Planning Application (Householder)

Application Number LU/261/15/HH

I would like to lodge my objection to the proposed "single storey rear extension" This involves the extension of the lower floor balcony by 1.0 metre – an 80% increase on the present balcony width and 100% on its length.

REAR ELEVATION
1:30

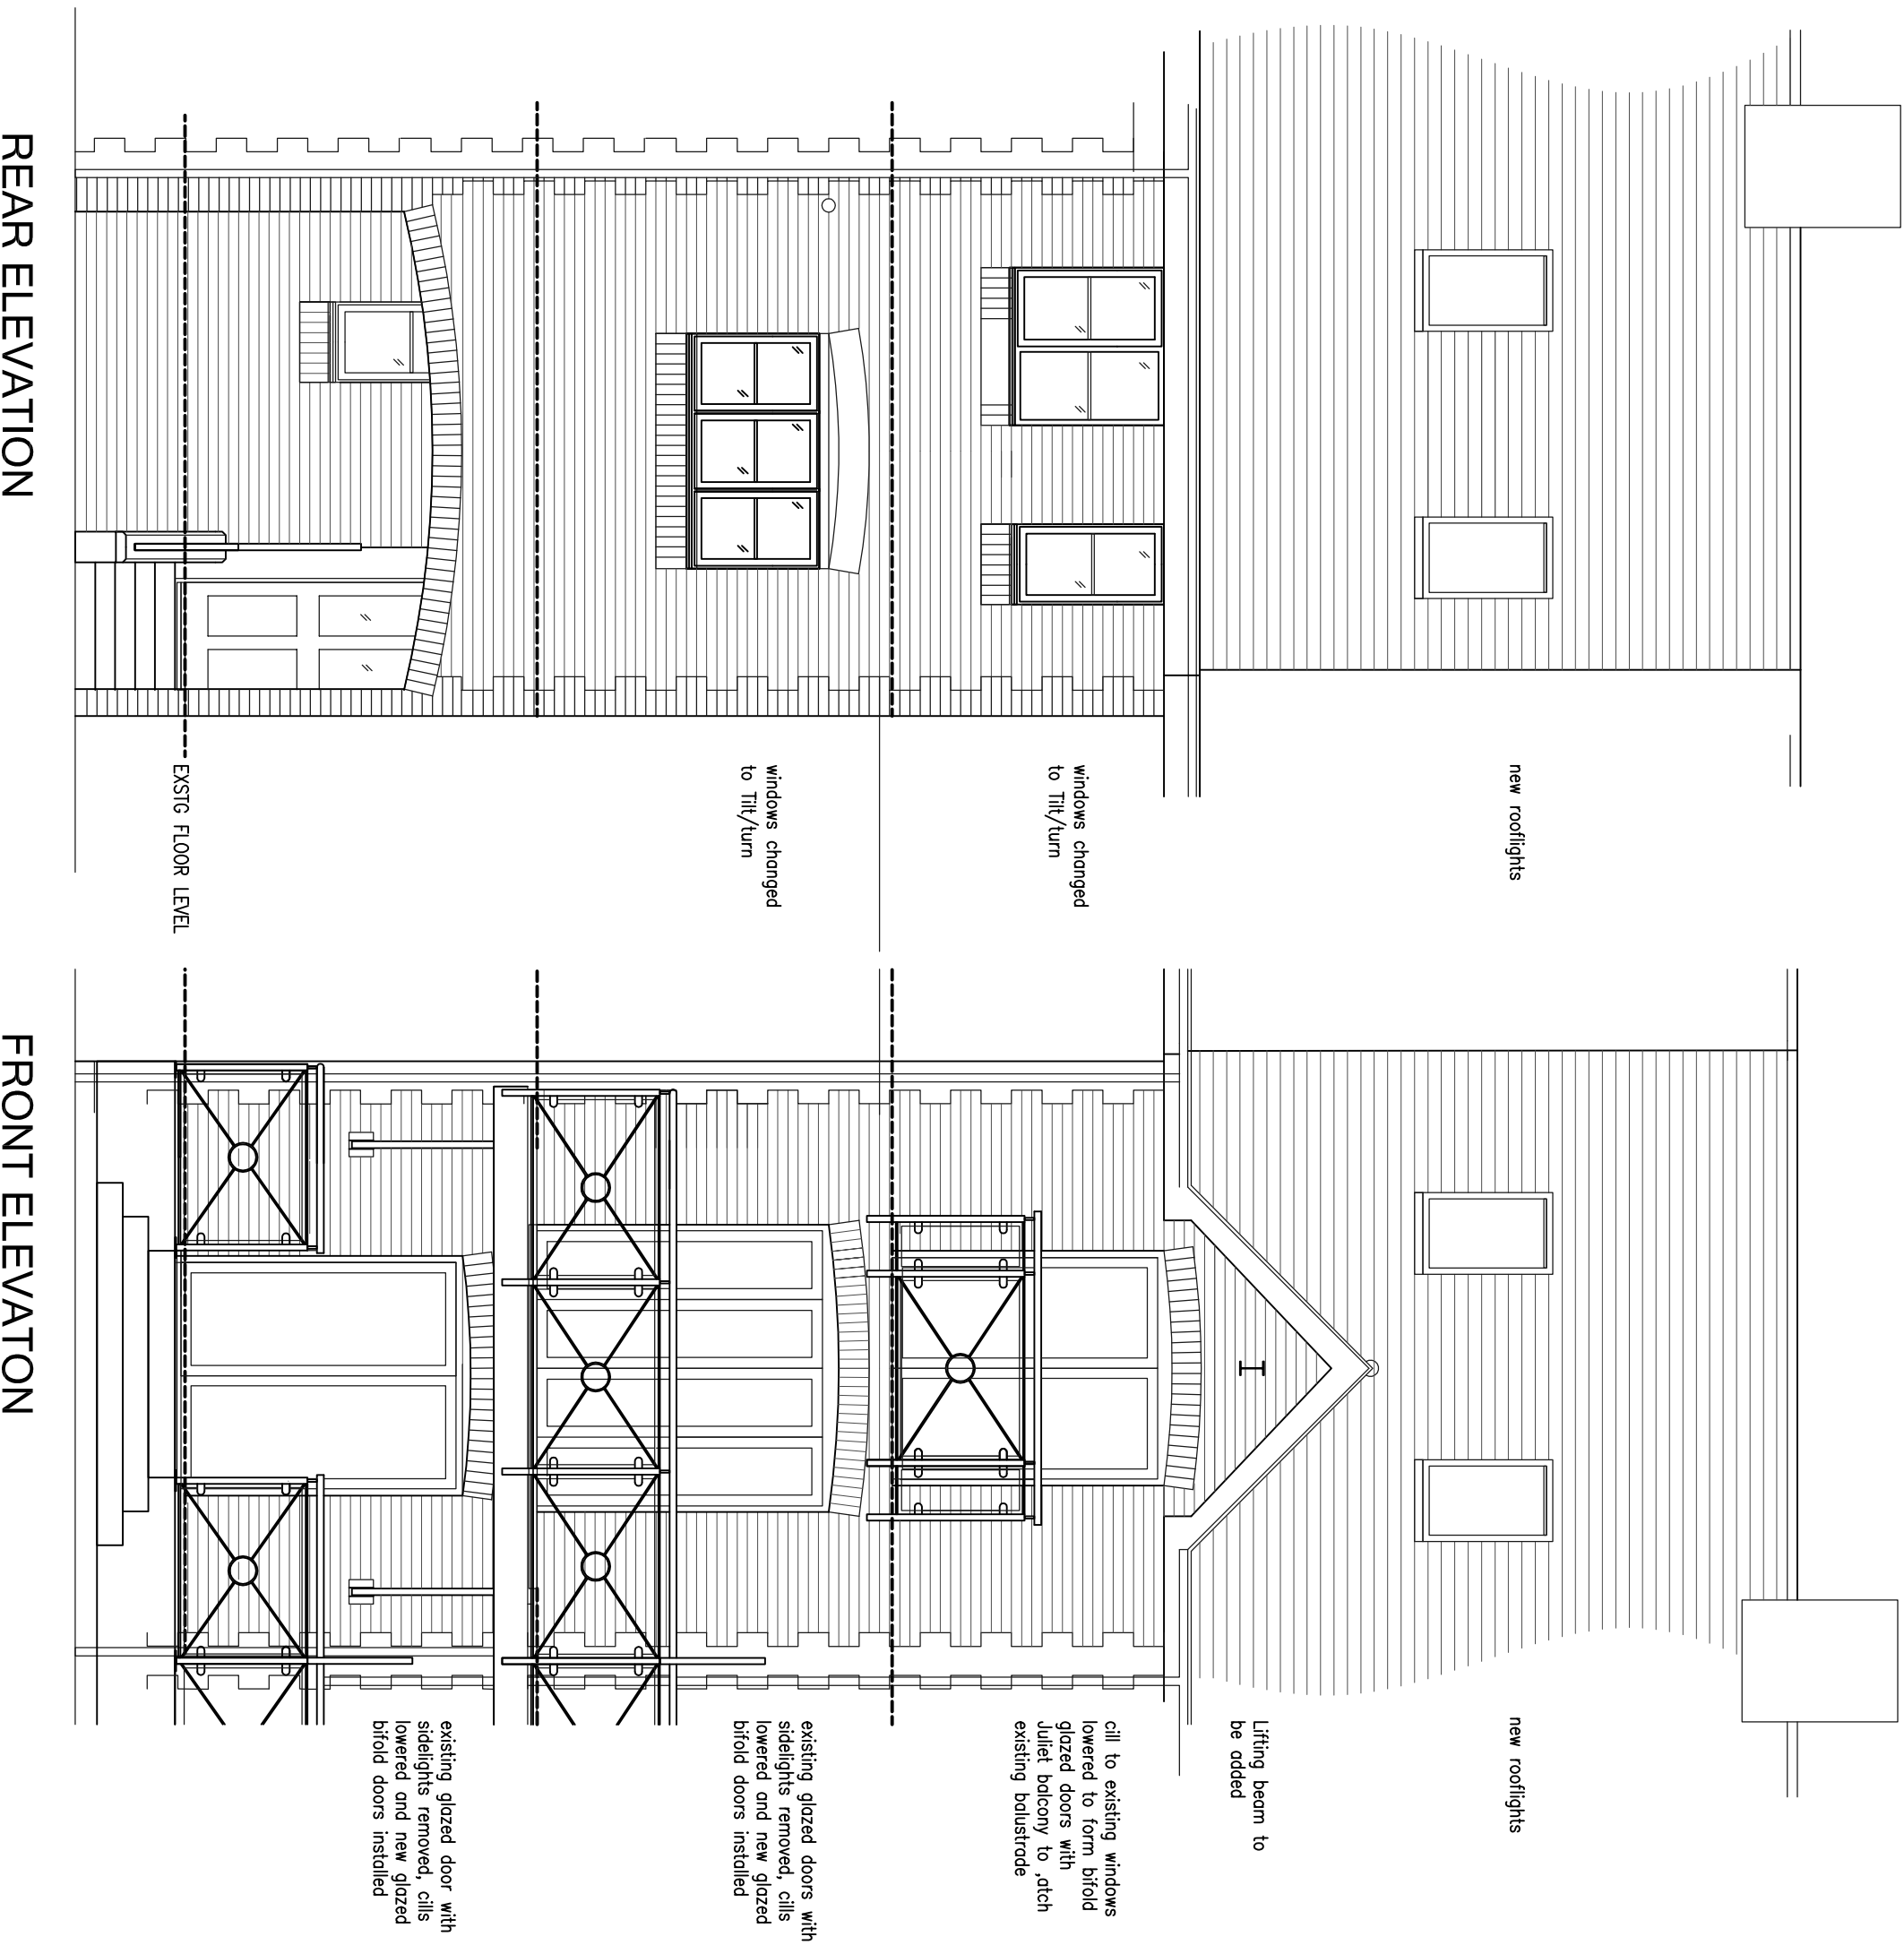
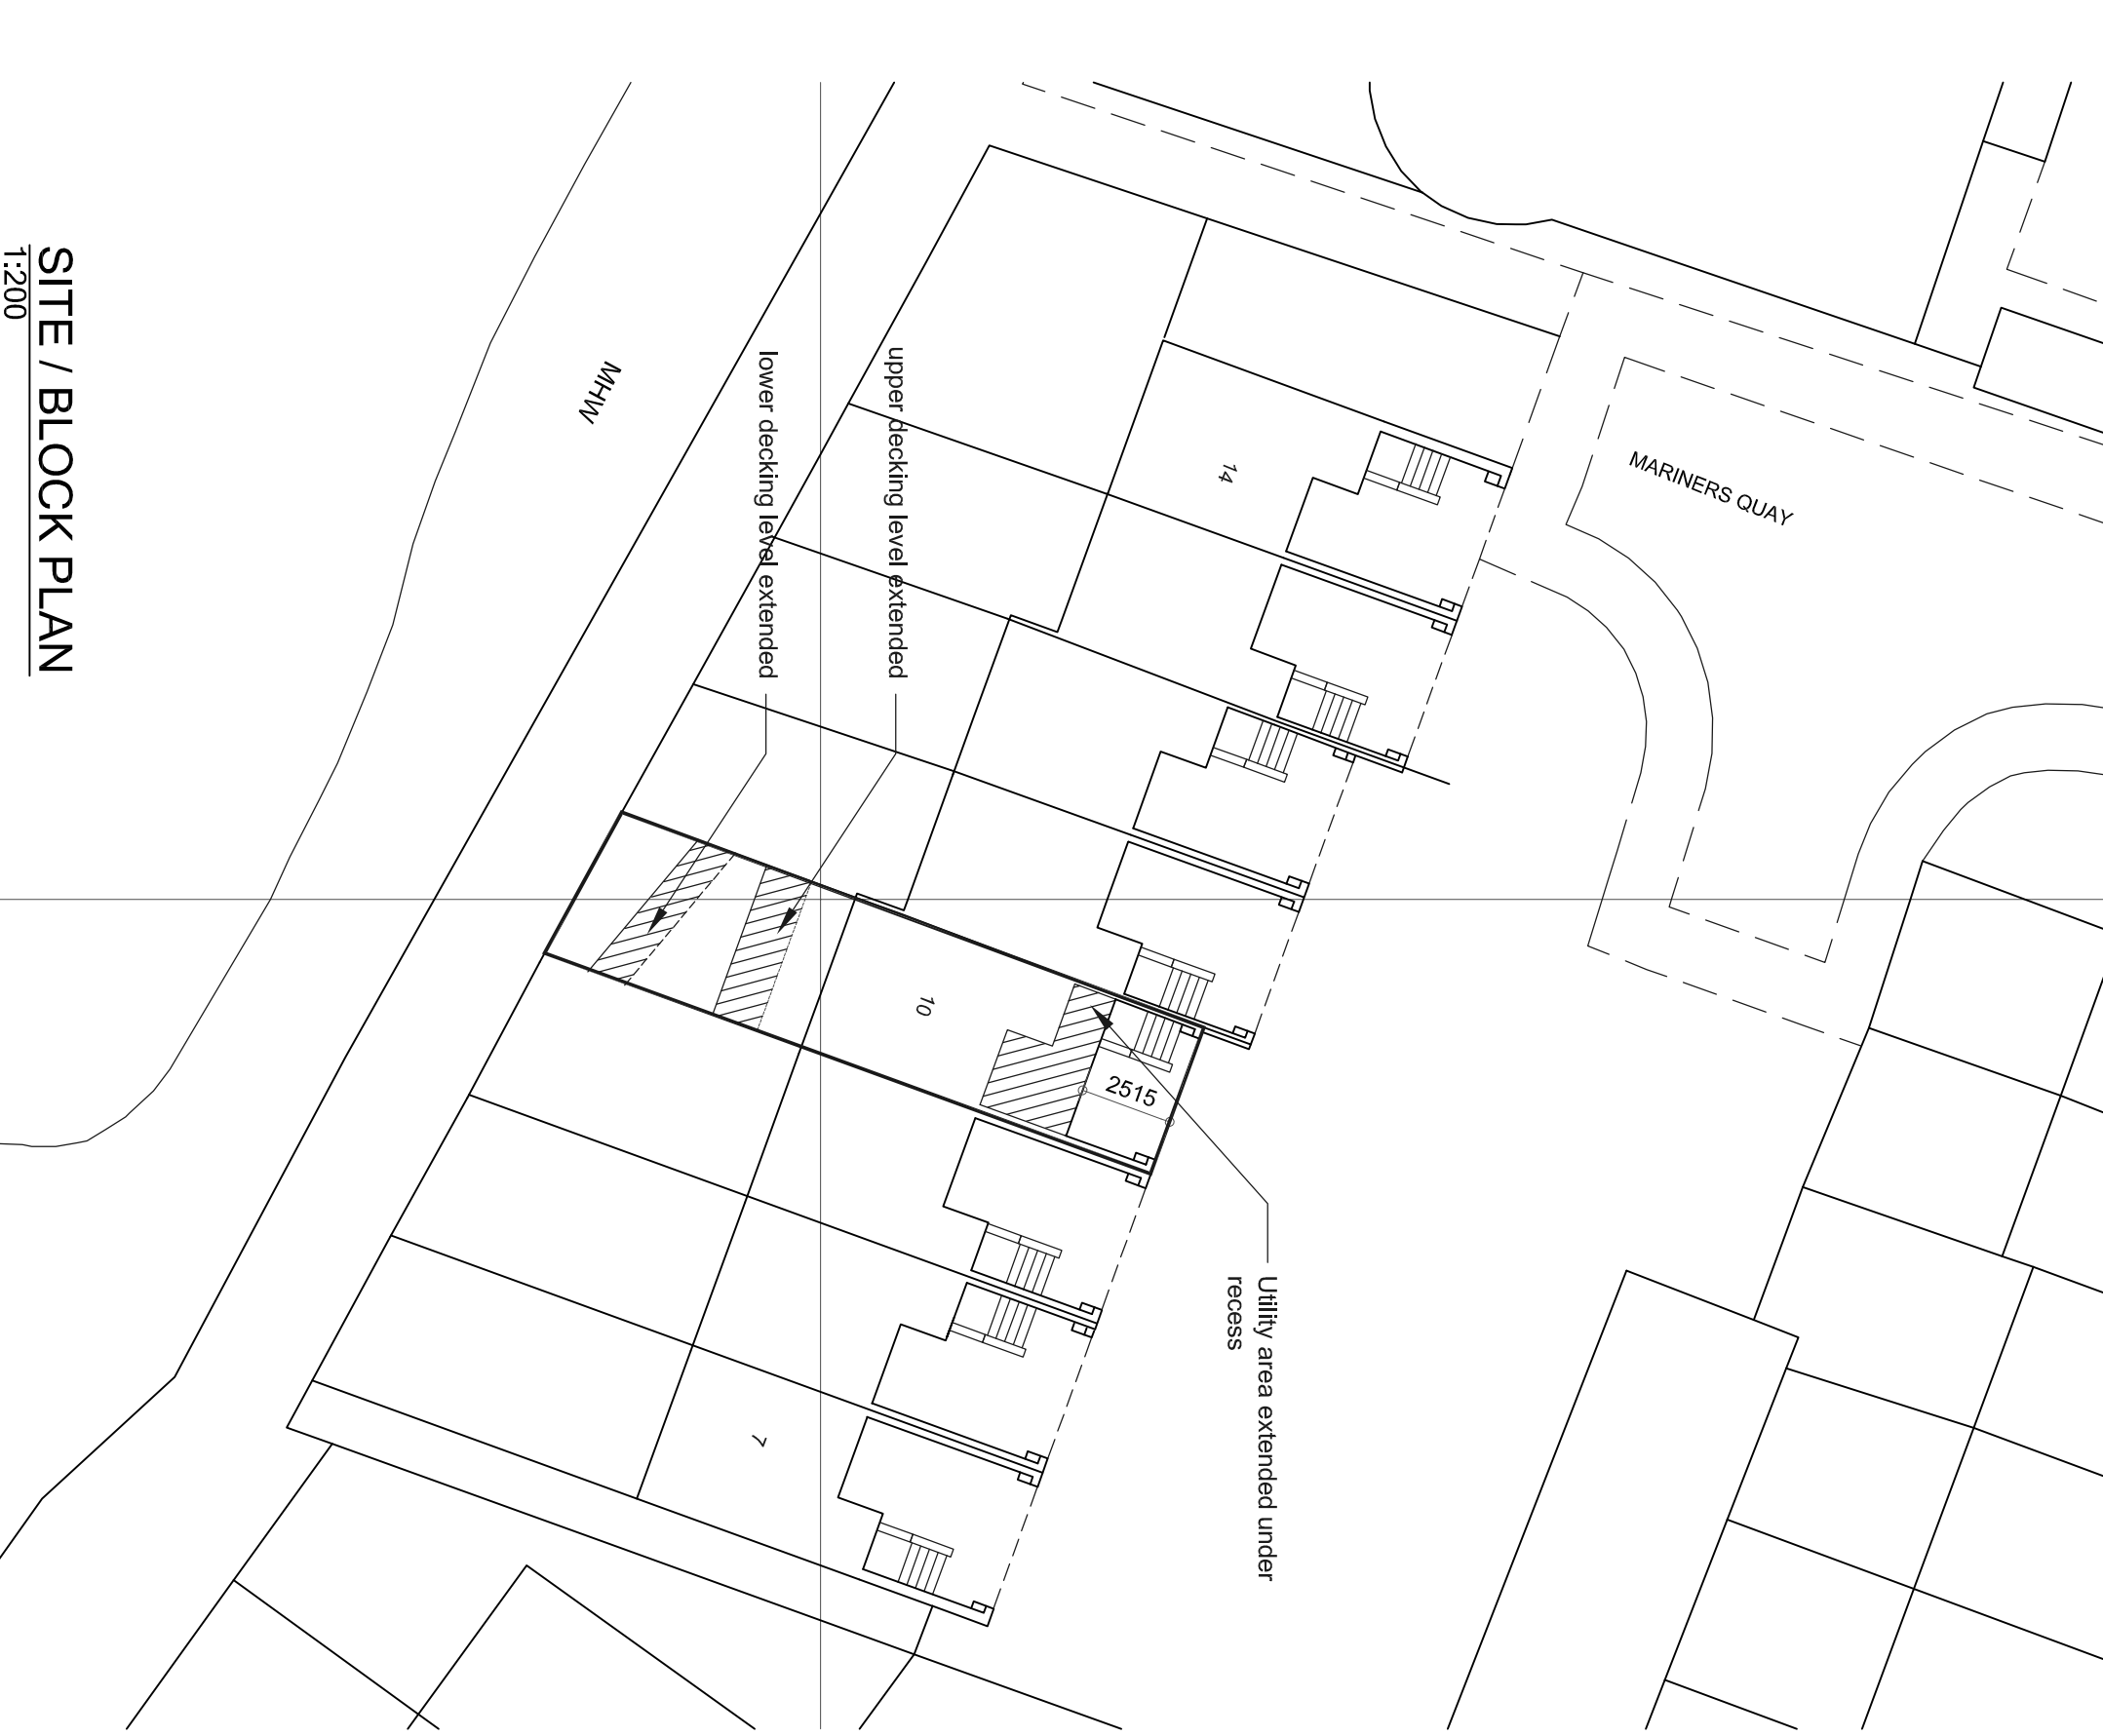
Secondly, the extension would overlook adjacent gardens from the 0.75 high balcony extension. This would adversely affect our privacy.
